From: Parish Clerk Billington and Langho Parish Council
<parishclerk@billingtonlanghopc.org>
Sent: 01 April 2025 18:20
To: Planning
Subject: 3/2025/0114 Kirkdale Road
Attachments: 3_2025_0114.pdf

At the meeting of Billington and Langho Parish Council held on the 31st March 2025, members of the public attended to give their objections to this planning application. On consulting with these people the Parish Council fully supports the objections.

Drawing file: planx_downloads / 25_0114_Proposed_Floor_Plans.pdf

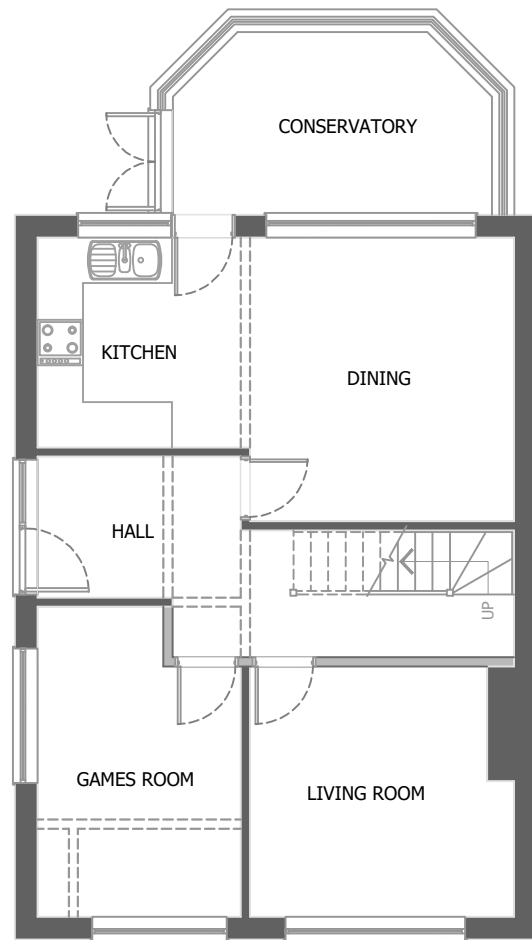
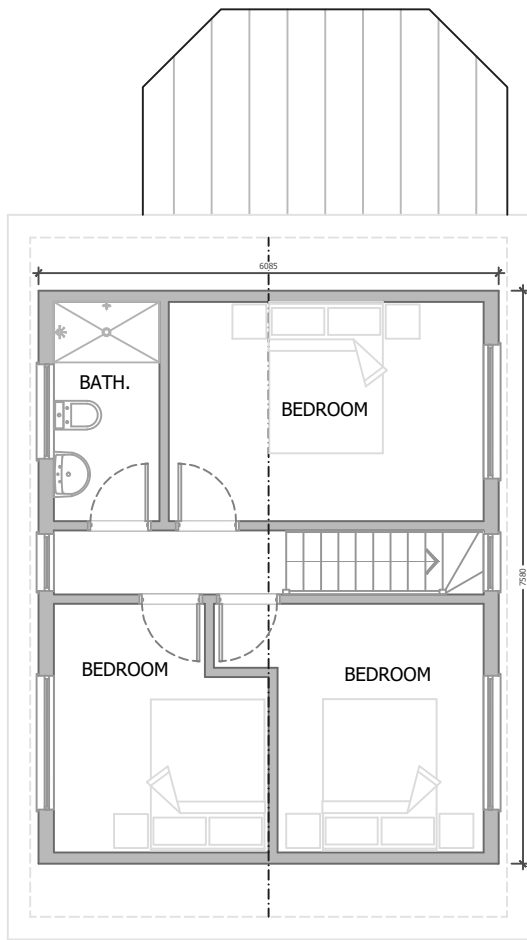
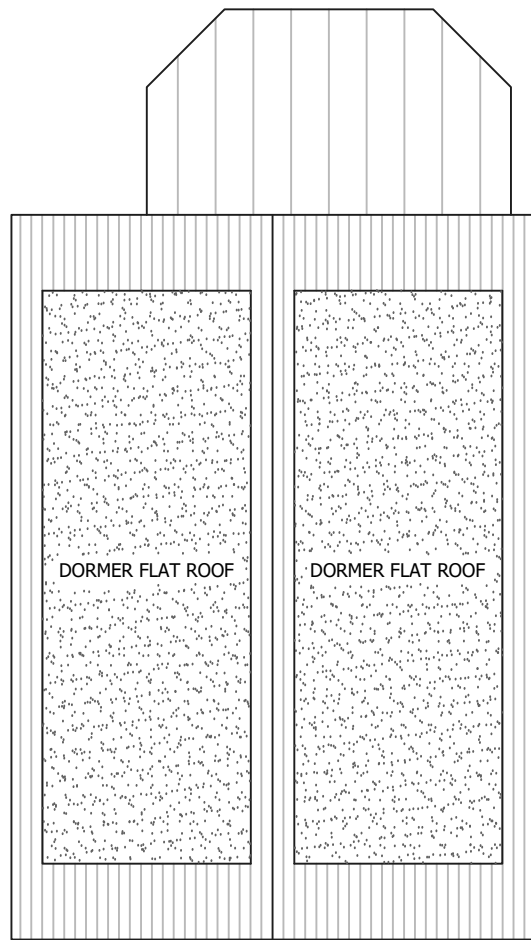
1. The proposed dormers are not facing the road and therefore will directly overlook both the kitchen and bathroom windows of the neighbour. This will give a lack of privacy to the neighbour.
2. The scale and density of the proposed plan is not in keeping with the area, this build is overbearing and unsympathetic to the area. This partly due to the scale of the build but also due to the fact that the build is higher up the hill to the neighbour.
3. The right to light will be obstructed, with the height of the build the ability to see the sky will be removed.
